CITY OF ALBUQUERQUE

Re: Midtown Self Storage - 4339 Cutler Ave NE
Request for Certificate of Occupancy- Transportation Development
Engineer's Stamp dated 07-22-16 (H17D105)
Certification dated 09-21-16

Re: Midtown Self Storage
4339 Cutler Ave NE
30-Day Temporary Certificate of Occupancy- Transportation Development
Engineer's Stamp dated 07-22-16 (H17D105)
Certification dated 09-21-16

Re: Midtown Self Storage
4339 Cutler Ave NE
Traffic Circulation Layout
Engineer's Stamp dated 07-22-2016 (H17D105)

DESIGN REVIEW COMMITTEE		CITY ENGINEER APPROVAL		MO./DAY/YR.	
City Project No. XXXX		Zone Map No. H-17-Z		Sheet 1 Of 1

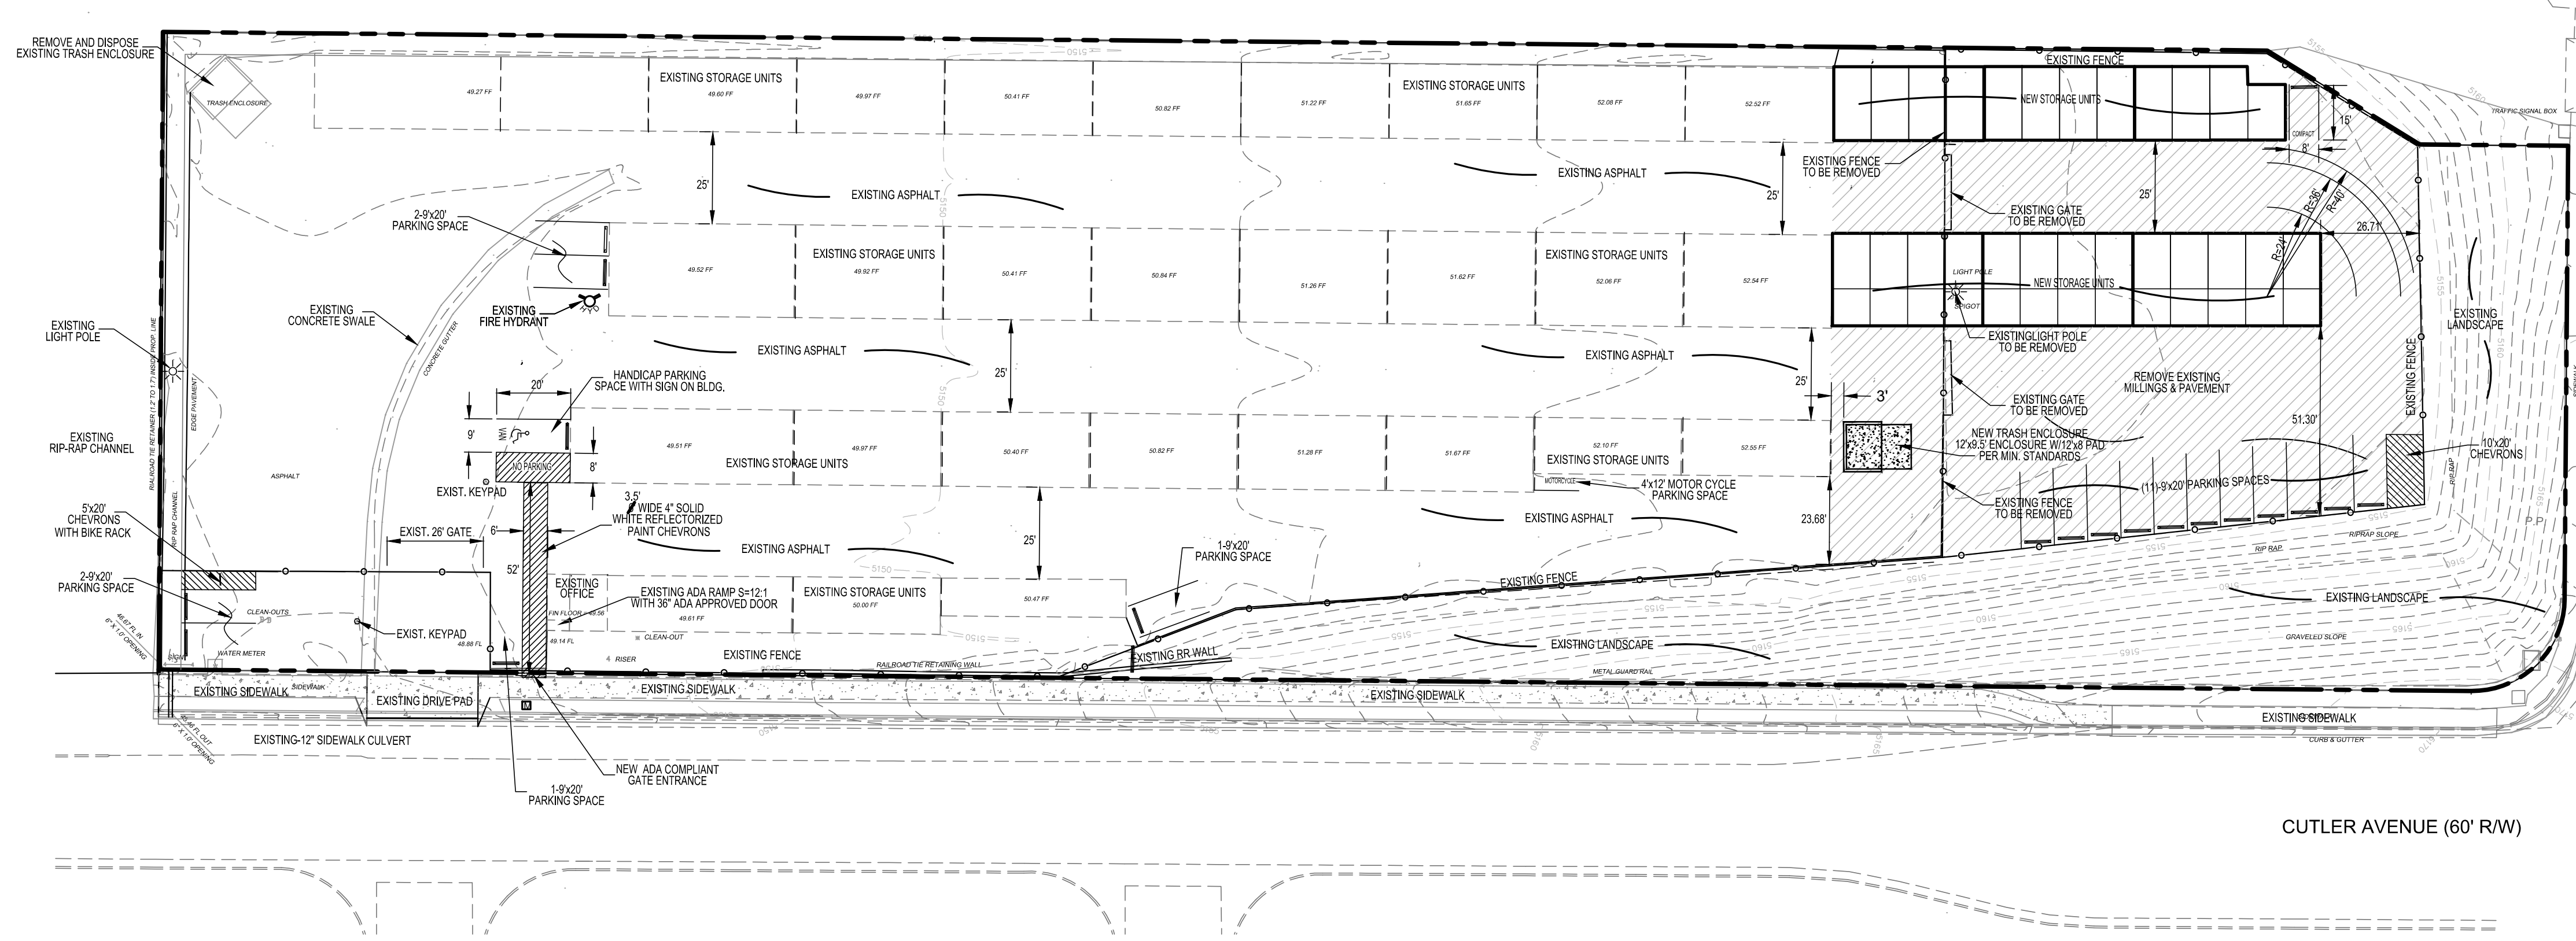
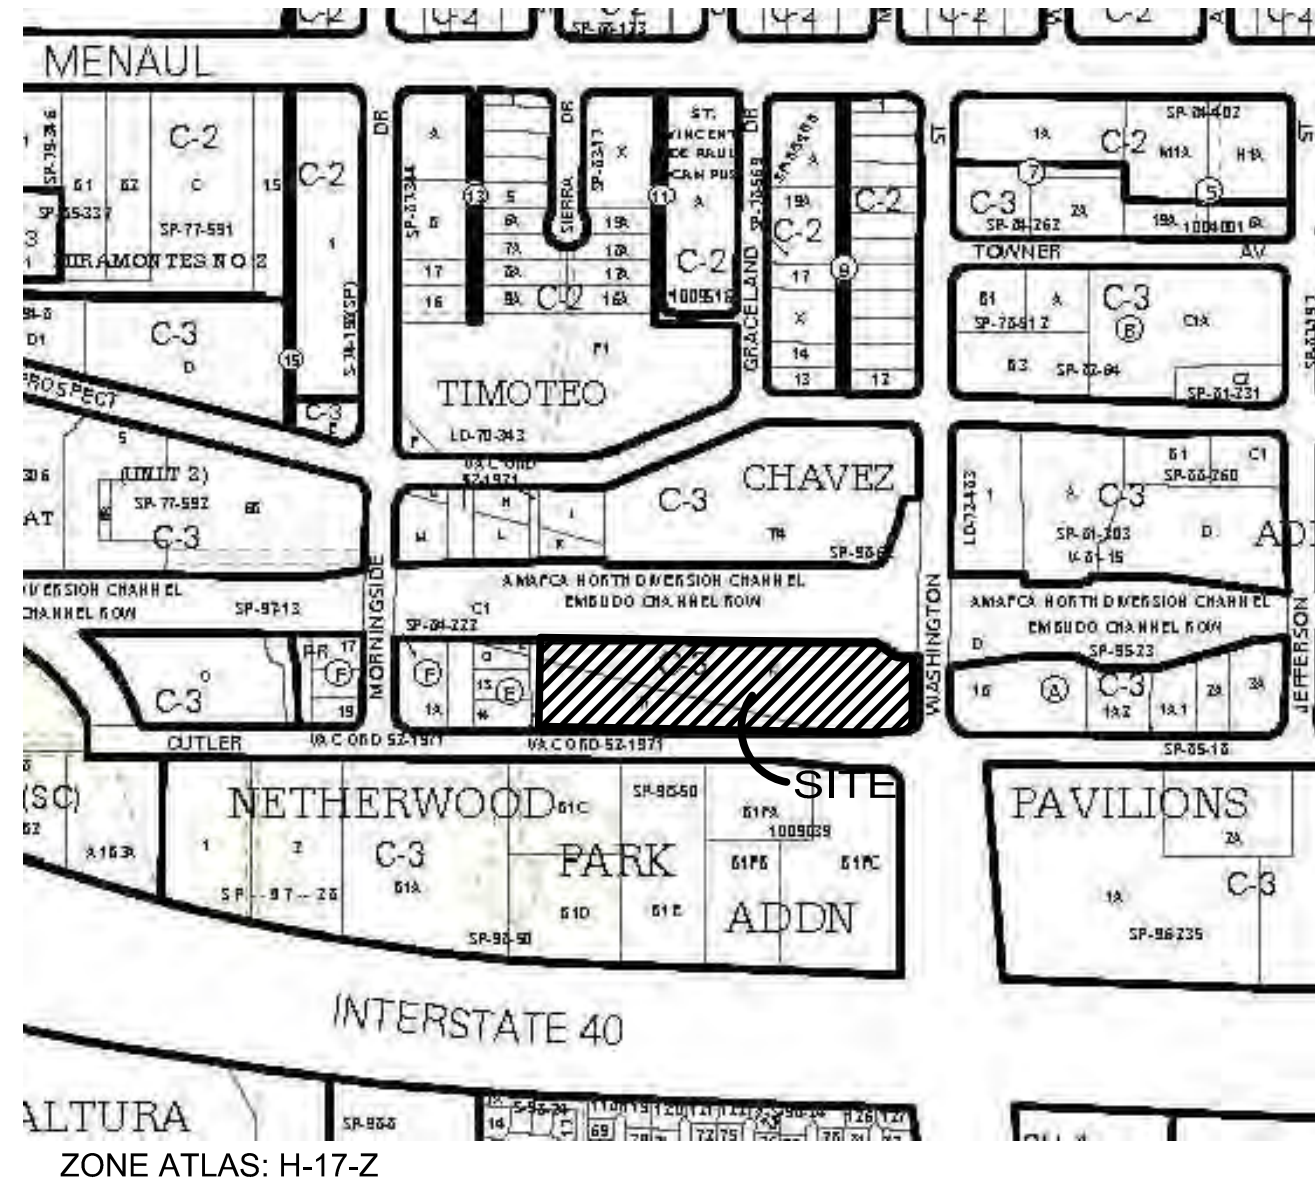
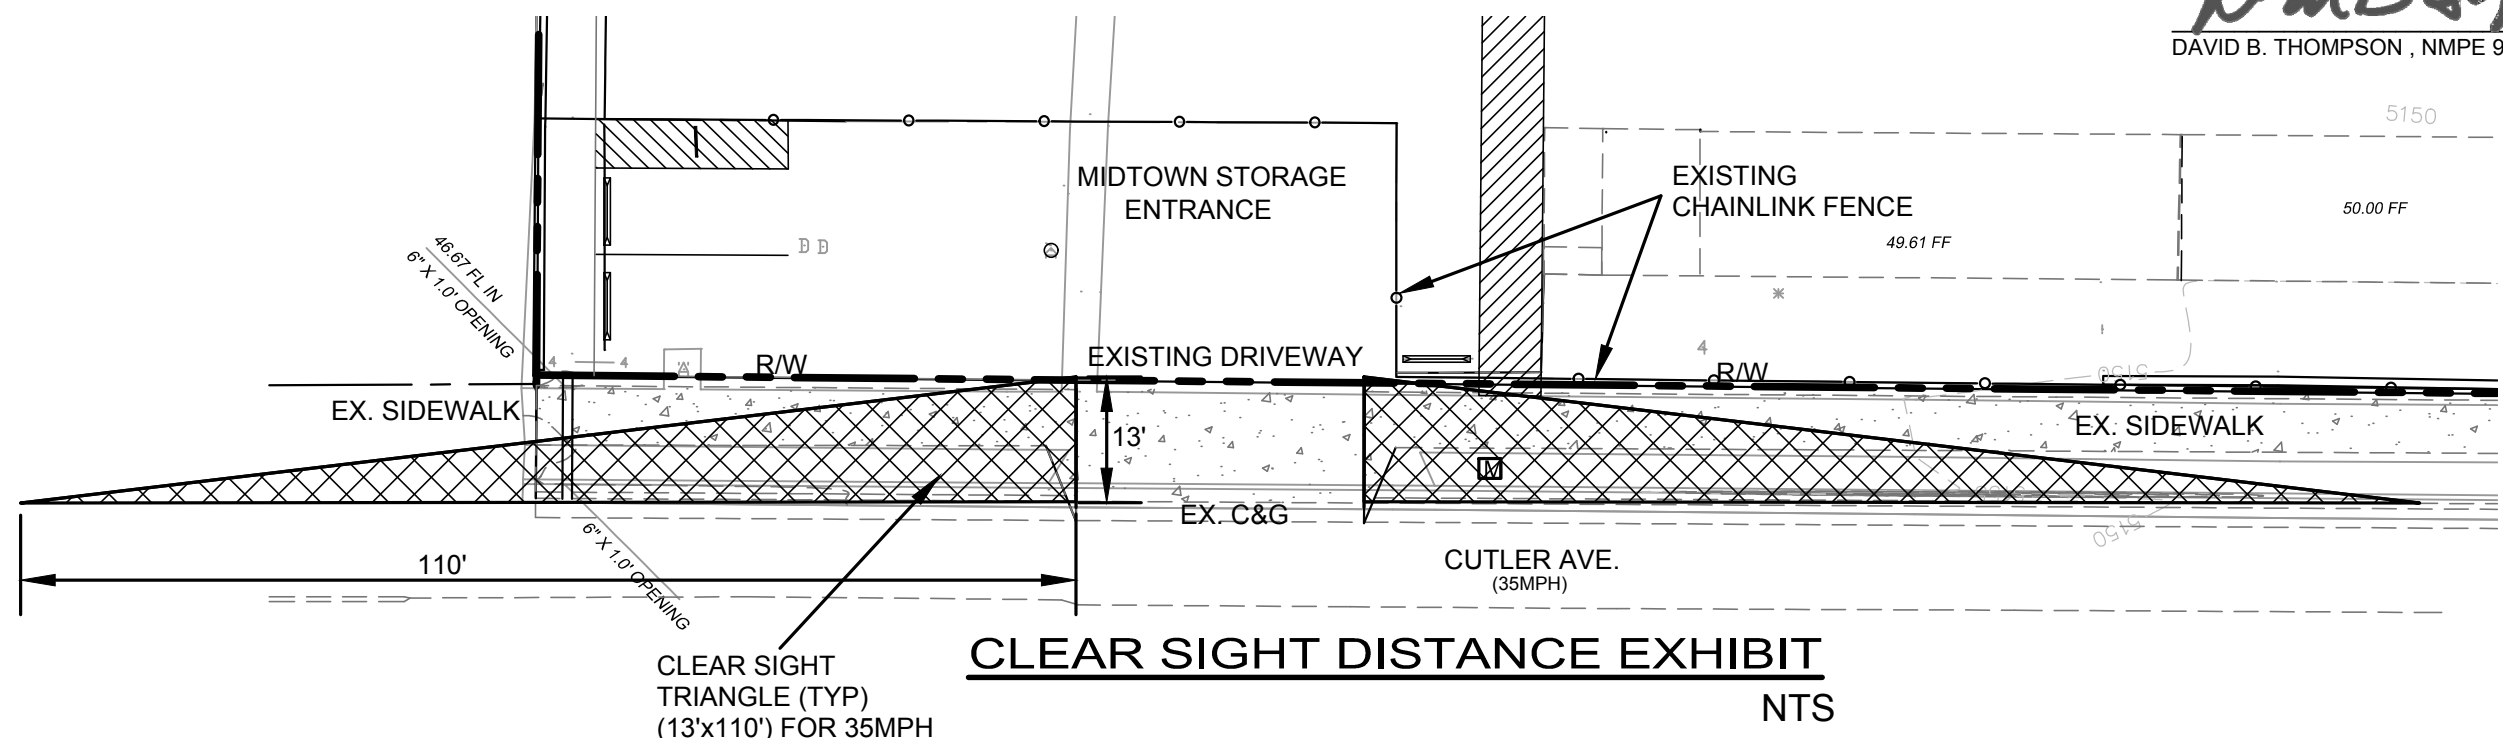
1. Per the zoning code, a 6 ft. wide ADA accessible pedestrian pathway is required from the public sidewalk to the building entrances. Please clearly show this pathway and provide details.
2. The approved TCL plan stamped and approved on 07-22-16 by Transportation must be the plan certified and submitted for Final TCL-CO.

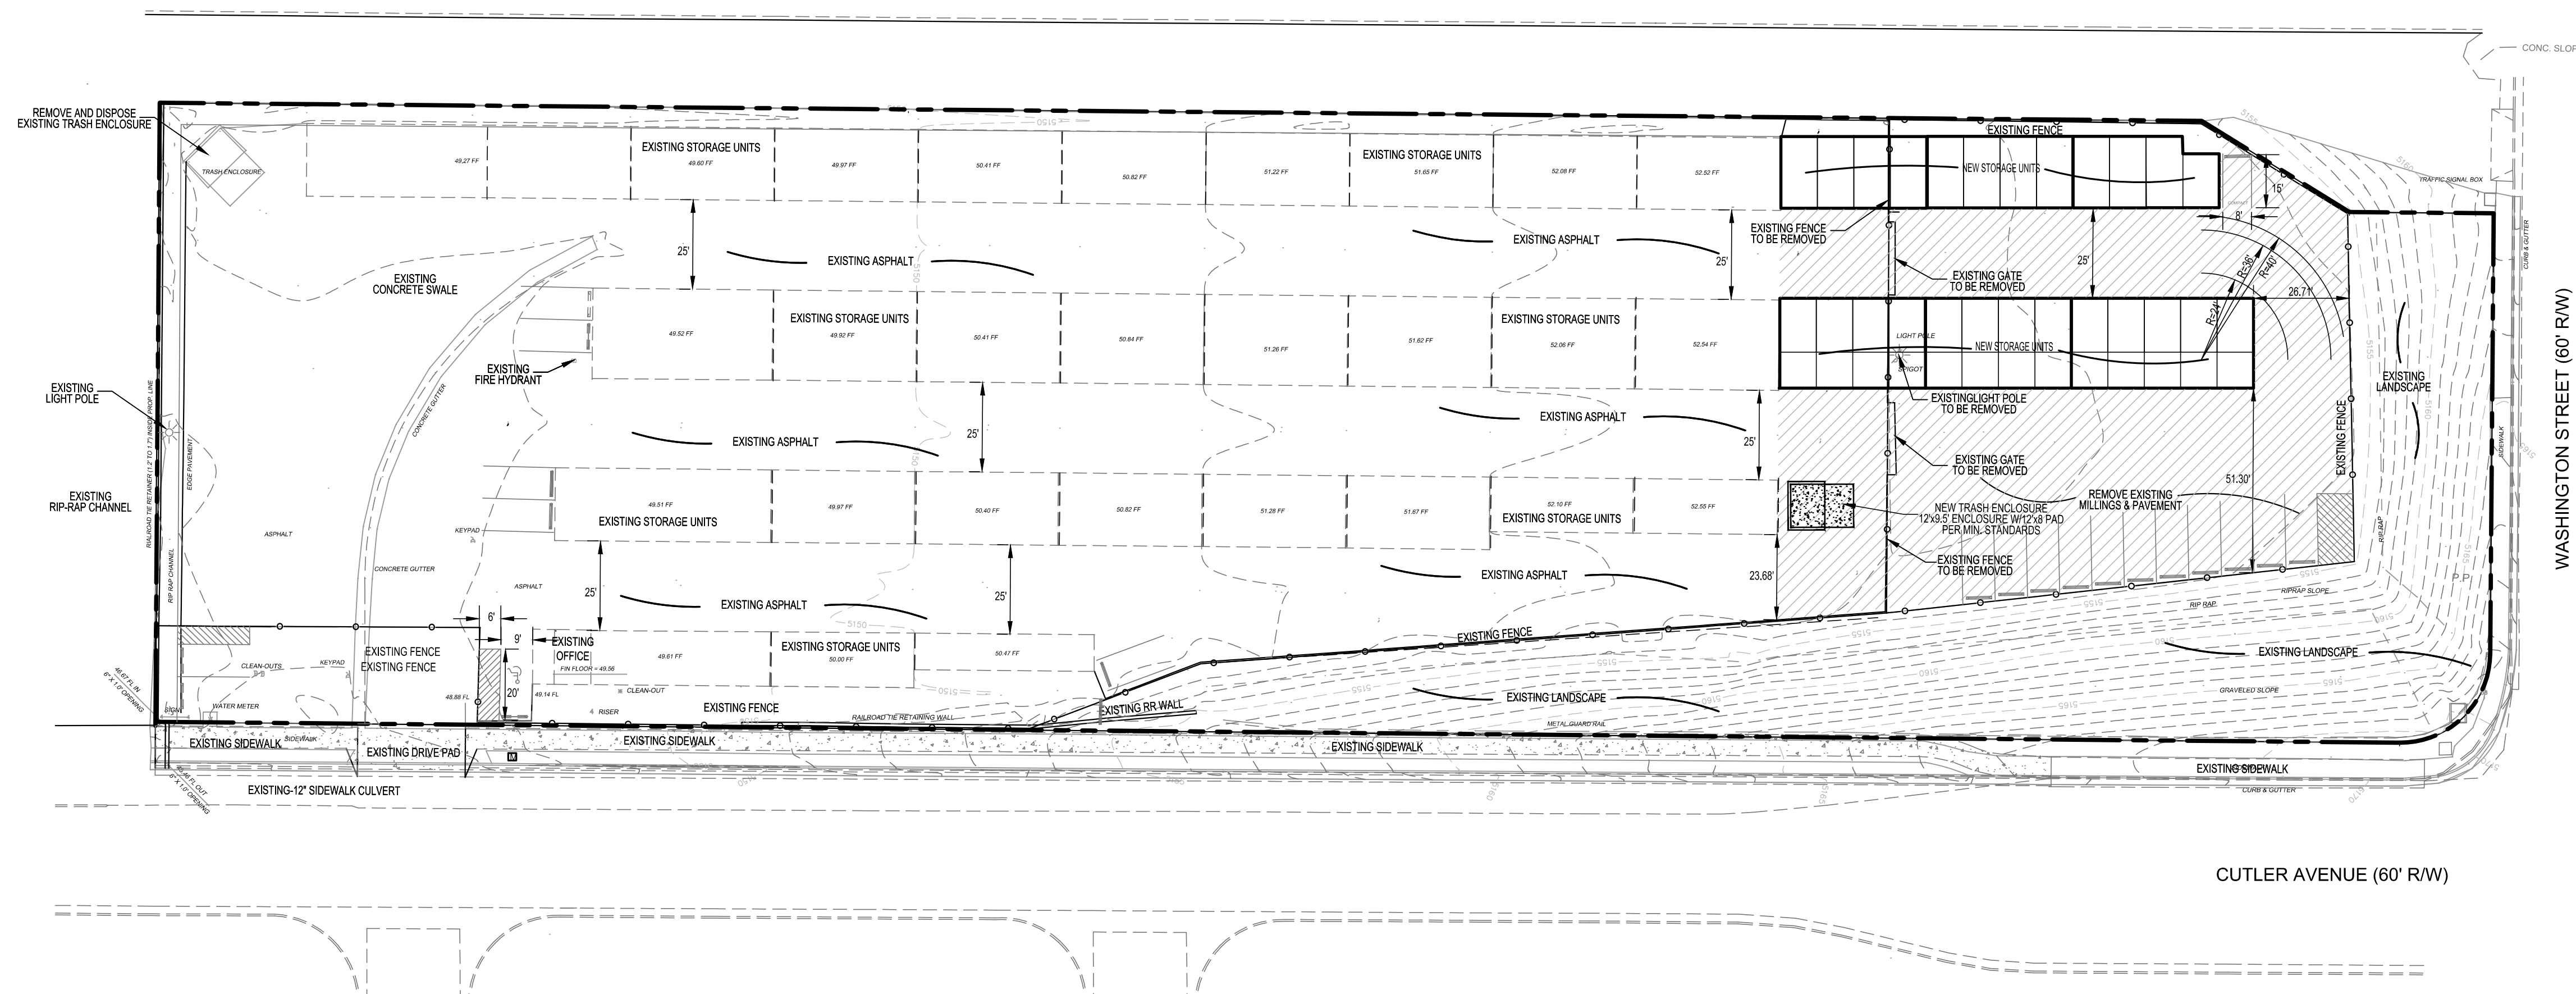
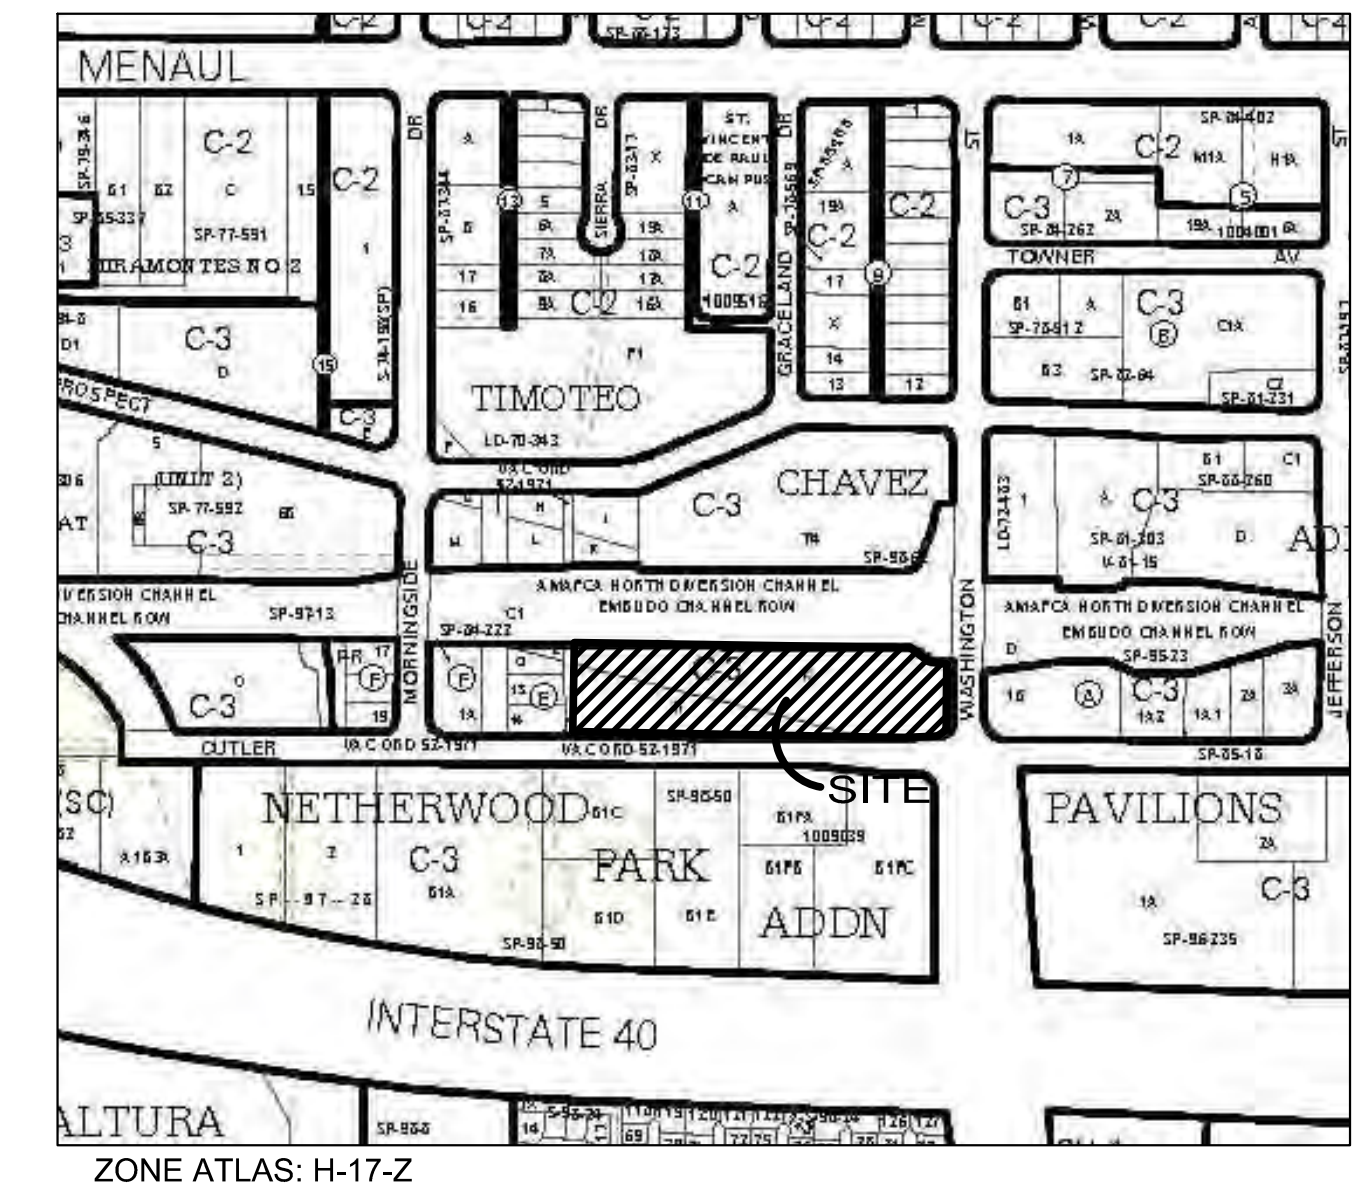
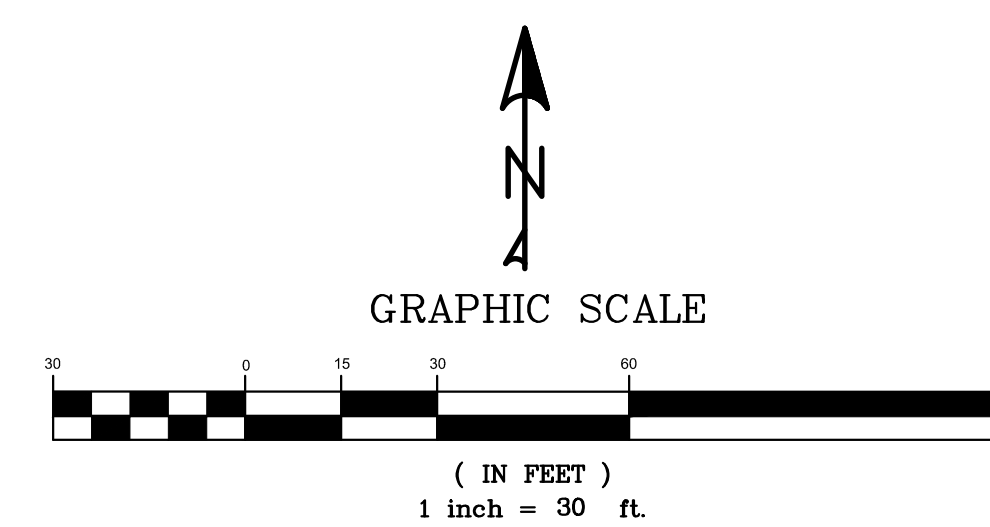
1. Please review and revise plan to provide all information listed on the attached Traffic Circulation Layout Check List.
2. Please refer to the attached Accessible Parking Checklist and revise the plan accordingly.

3. Please list the width and length for all existing and proposed parking spaces.
4. The handicap accessible spaces must be a minimum of 8.5 ft. in width.

5. The handicap accessible spaces must include an 8 ft. wide van access aisle; all other aisles should be 5 ft. in width.
6. The ADA accessible parking sign must have the required language per 66-7-352.4C NMSA 1978 **"Violators Are Subject to a Fine and/or Towing."** Please call out detail and location of HC signs.

7. The ADA access aisles shall have the words **"NO PARKING"** in capital letters, each of which shall be at least one foot high and at least two inches wide, placed at the rear of the parking space so as to be close to where an adjacent vehicle's rear tire would be placed. (66-1-4.1.B NMSA 1978)

8. Maximum aisle lengths of 400 ft. without internal circulation between aisles.
9. Per DPM, a 6 ft. wide ADA accessible pedestrian pathway is required from the public sidewalk to the building entrances. Please clearly show this pathway and provide details.

10. Per DPM, a 6 ft. wide ADA accessible pedestrian pathway is required from the HC parking stall access aisles to the building entrances. Please clearly show this pathway and provide details. ADA accessible pedestrian pathway cannot be located behind vehicular traffic.

11. Provide minimum motorcycle parking per off-street parking spaces (Zoning Code, 14-16-3-1,C)
12. Required bicycle parking for residences, nonresidential, schools, and other facilities (Zoning Code, 14-16-3-1, B)

13. Service vehicle and/or refuse vehicle maneuvering must be contained on-site; provide a copy of refuse approval.
14. It is not apparent what type of pavement surface is being proposed. A hard driving surface will be required as part of this proposed project for parking area and drive aisles.

15. Please add the following note to the clear sight triangle: "Landscaping and signage will not interfere with clear sight requirements. Therefore, signs, walls, trees, and shrubbery between 3 and 8 feet tall (as measured from the gutter pan) will not be acceptable in this area."

16. Please add a note on the plan stating "All improvements located in the Right of Way must be constructed through the COA DRC work order process."
17. All broken or cracked sidewalk must be replaced with sidewalk and curb & gutter. A build note must be provided referring to the appropriate City Standard drawing.
